Final Report - Corrections Required **Application No. ANEX-24-0006**

Description : Matrix Design Group on behalf of Colorado Springs Equities LLC is submitting a serial annexation petition for seven parcels and Land Use Plan/Rezoning exhibit for a portion of the subdivision known as Rock Creek Mesa.

Document Filename : 224.023-LEGAL-RCM ANNEX 6.pdf

ROCK CREEK MESA ADDITION NO. 6

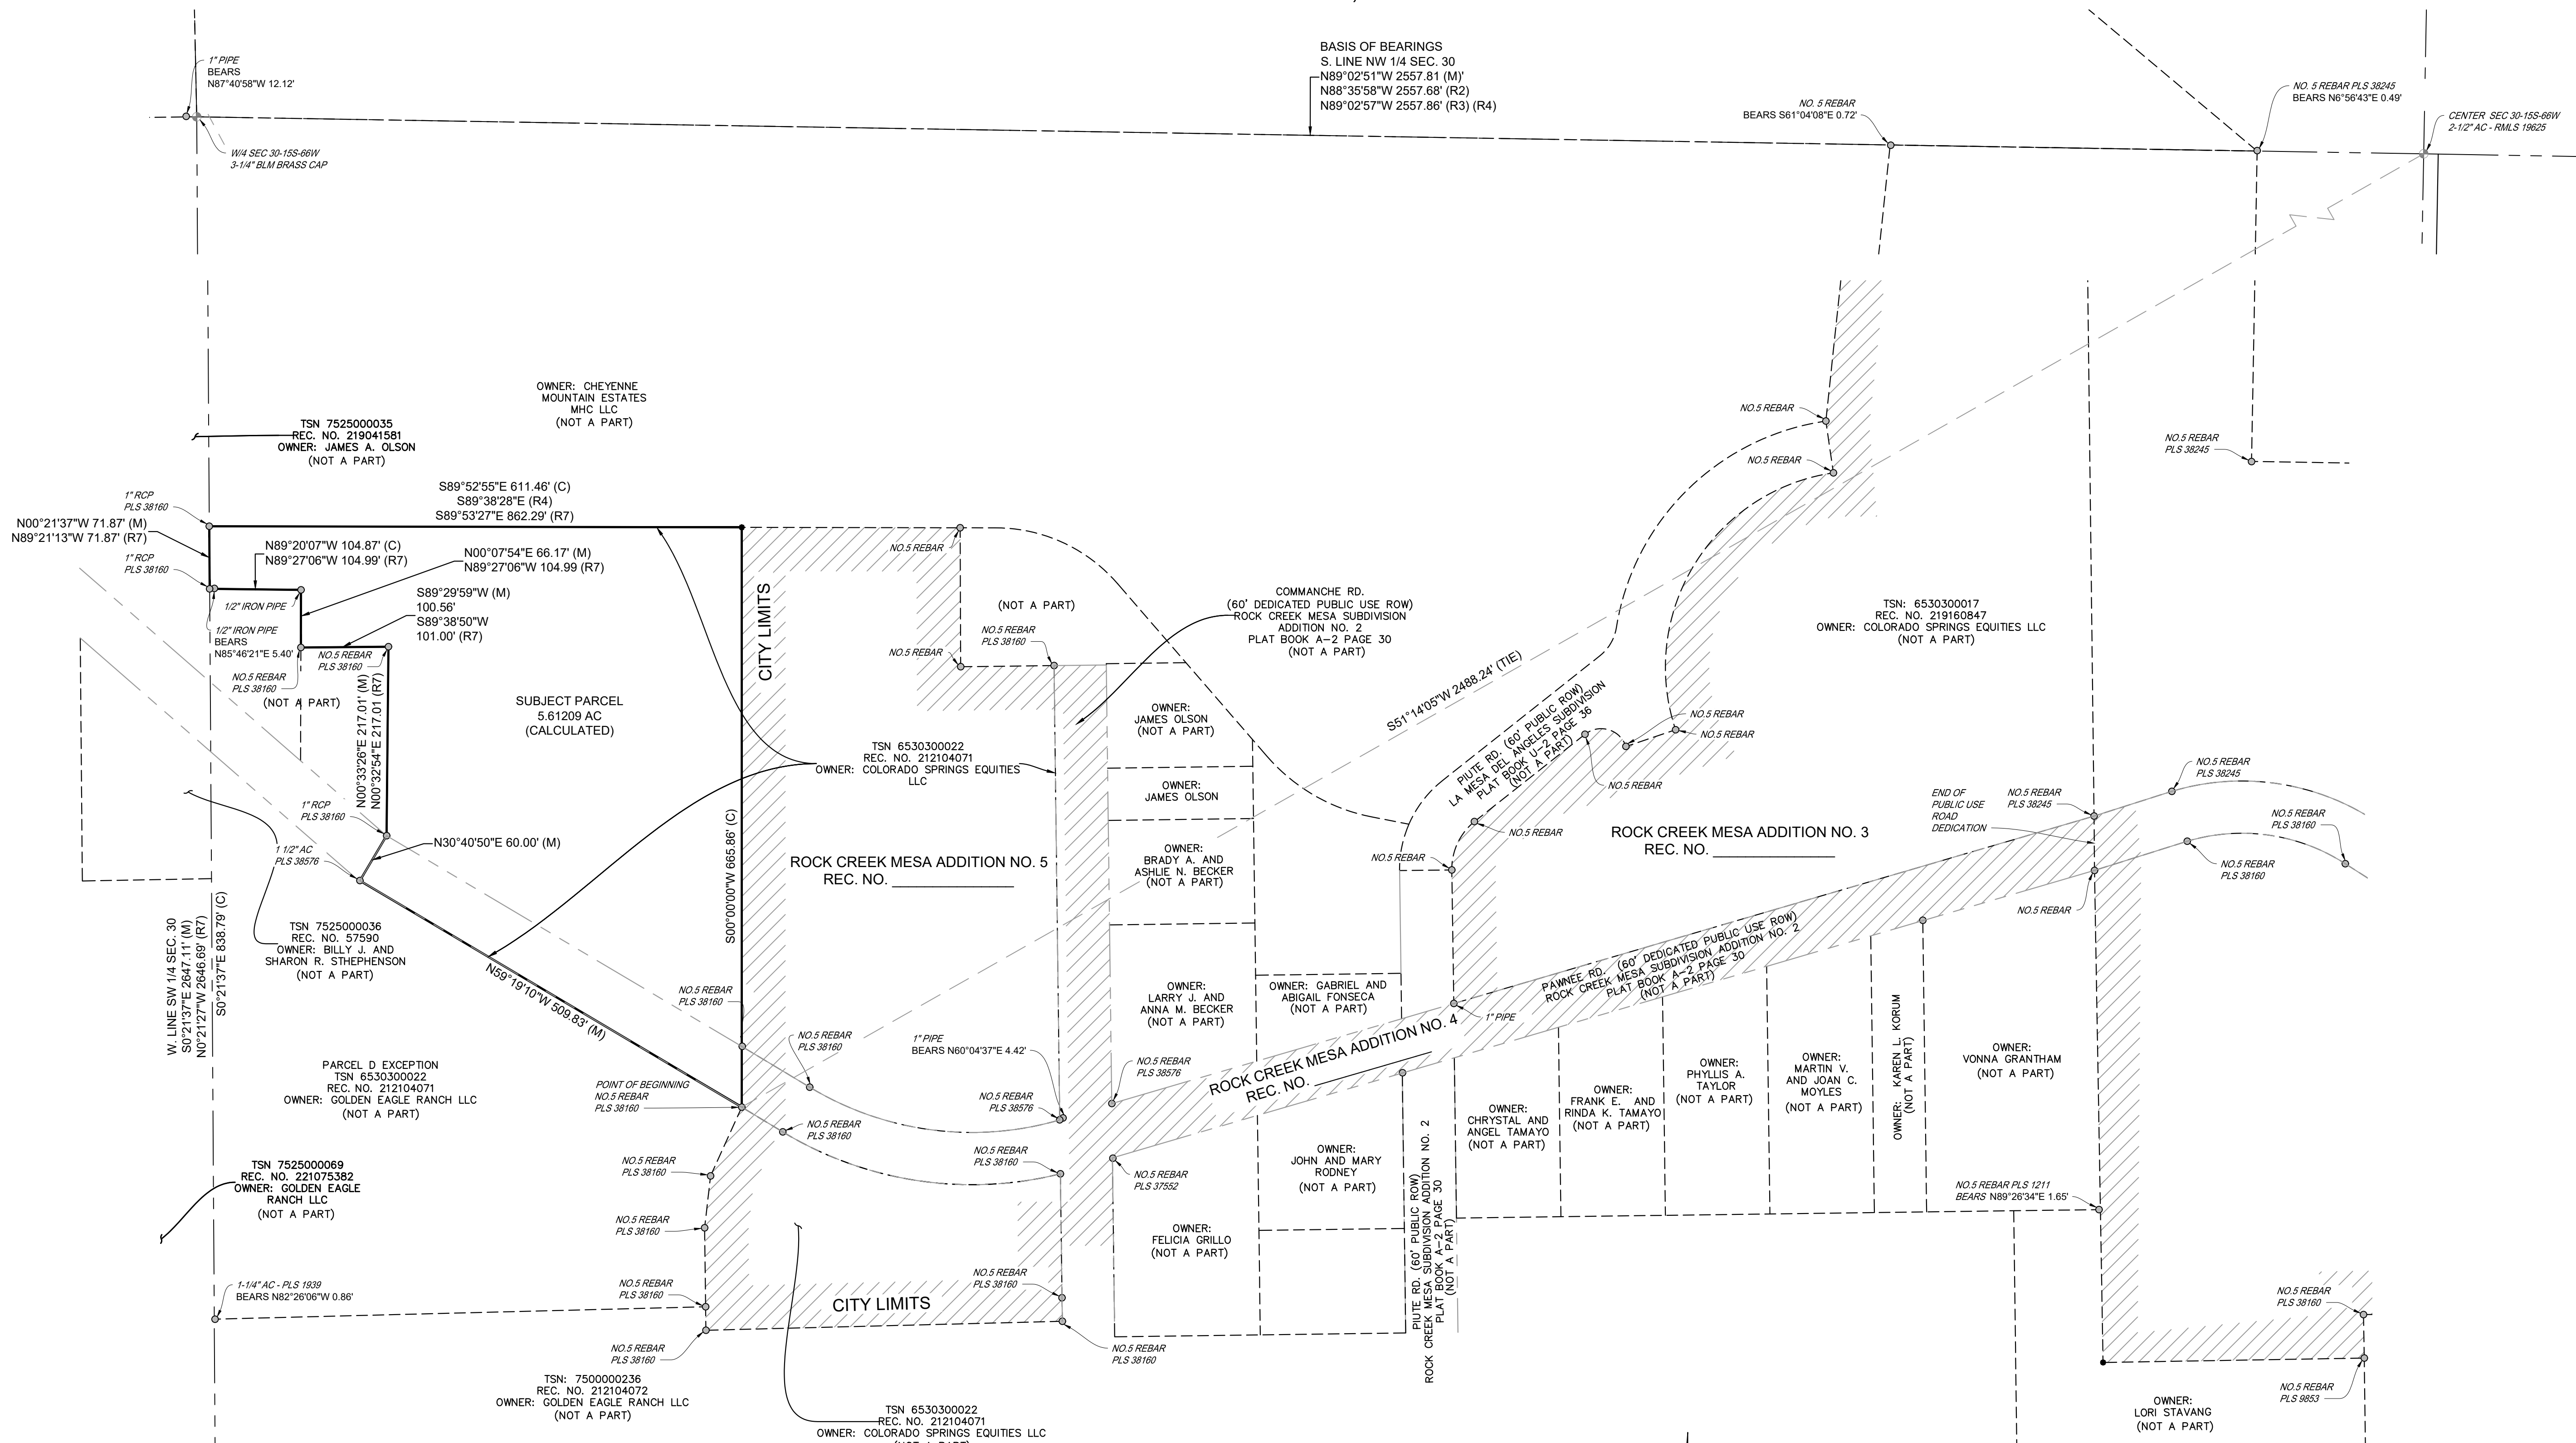
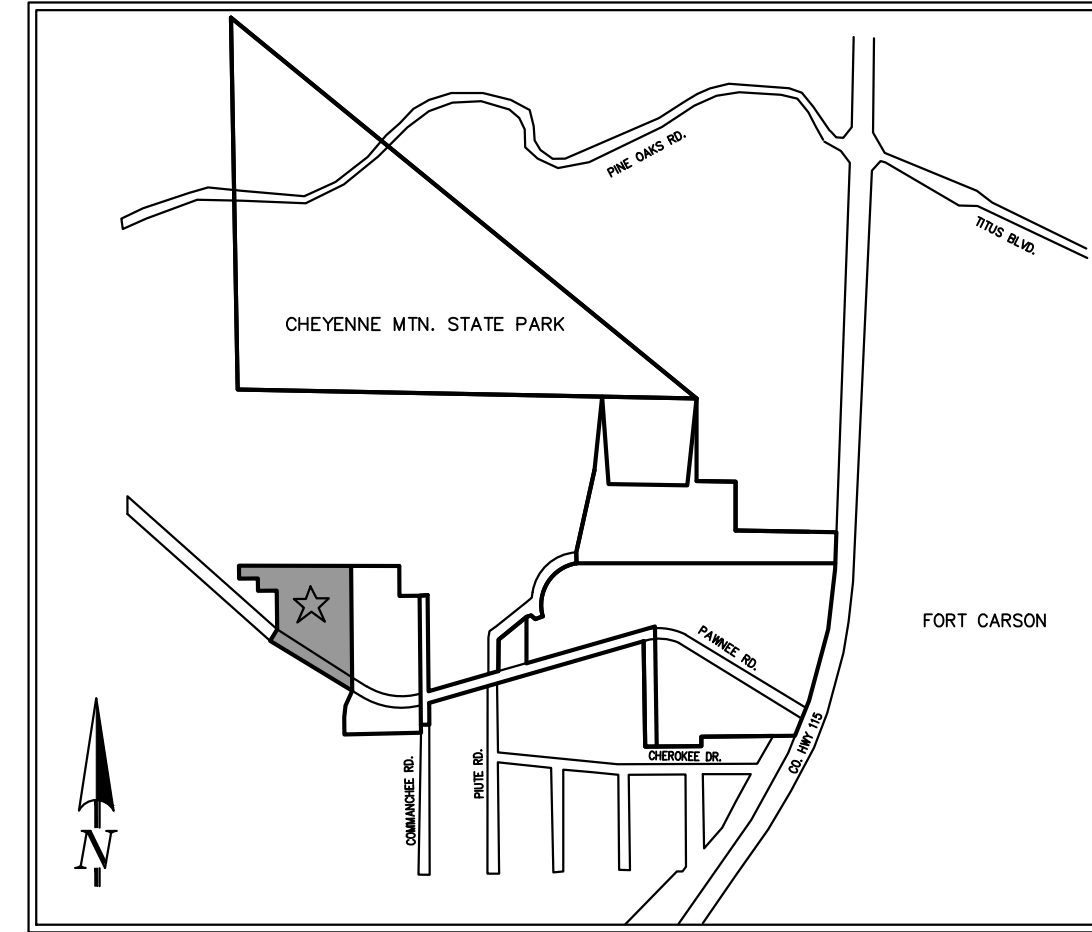
Comment ID	Page Reference	Reviewer : Department	Review Comments
17	1	Gabe Sevigny : Planning	Be sure that any updates on the Annexation Plat are reflected here and vice versa
18	1	Gabe Sevigny : Planning	Add ANEX-24-0006
20	1	Cory Sharp : Planning	Please revise exhibit A to: Rock Creek Mesa Addition No. 6
21	1	Cory Sharp : Planning	Please add the area at the end of the legal description
